WELWYN HATFIELD COUNCIL – DEVELOPMENT CONTROL
DELEGATED REPORT

APPLICATION No:	S6/2009/2749/FP
------------------------	------------------------

The application seeks full planning permission for the 'erection of a two storey residential extension, first floor granny annexe and B1 (office) replacement following demolition of existing ground floor offices.'

EAST ELEVATION
SCALE 1:100

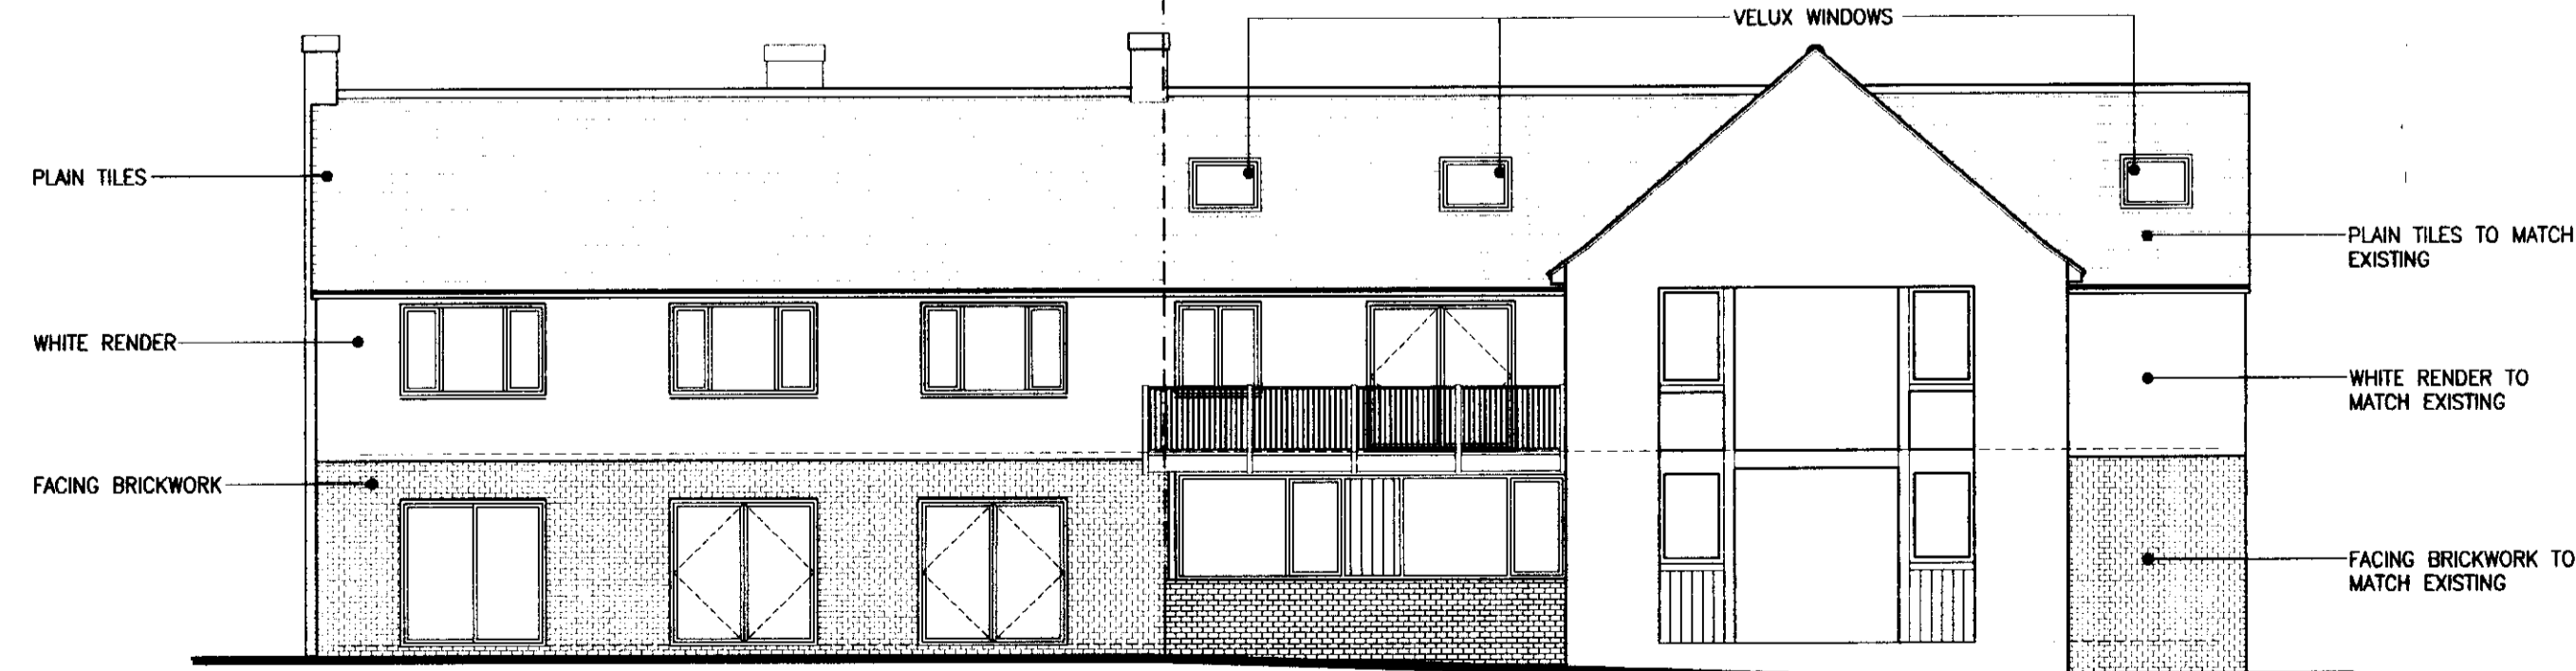
The proposed new resultant floor areas comprises approximately 174 sqm at ground level and approximately 228 sqm at first floor level giving an overall resultant floor area of approximately 402 sqm. This would result in an overall increase in new habitable residential floor areas since the 'original dwelling was built of 250 sqm which is approximately 164 % increase of floor area compared to the 'original' dwelling.

In regards to an assessment of height and overall mass, the proposed extensions would not increase the height of the 'original' dwelling, but would add significantly further to its overall mass. Although the east side of the dwelling would remain in its existing form, the resultant building would increase significantly to the west with the proposed two storey extensions. This increase in mass along with the increase in

habitable floor areas of 164% would result in a disproportionate addition over and above the size of the 'original' dwelling. The proposal is therefore considered to represent inappropriate development in the Green Belt. The proposal would fail the requirements of Criteria (i) of Policy RA3 and also PPG2.

- 1. The cumulative effect of the proposed development would, when considered in relation to previous extensions to the dwellinghouse, result in disproportionate additions over and above the size of the original dwelling due to the increase in the resultant floor area, size, bulk and mass. This would significantly reduce the openness of this part of the Green Belt to the harm of the rural character of the area contrary to the requirements of Policy RA3 of the Welwyn Hatfield District Plan 2005 and Planning Policy Guidance Note 2 (Green Belt). There are no very special circumstances which have been advanced to justify a departure from the Green Belt Policies of restraint.
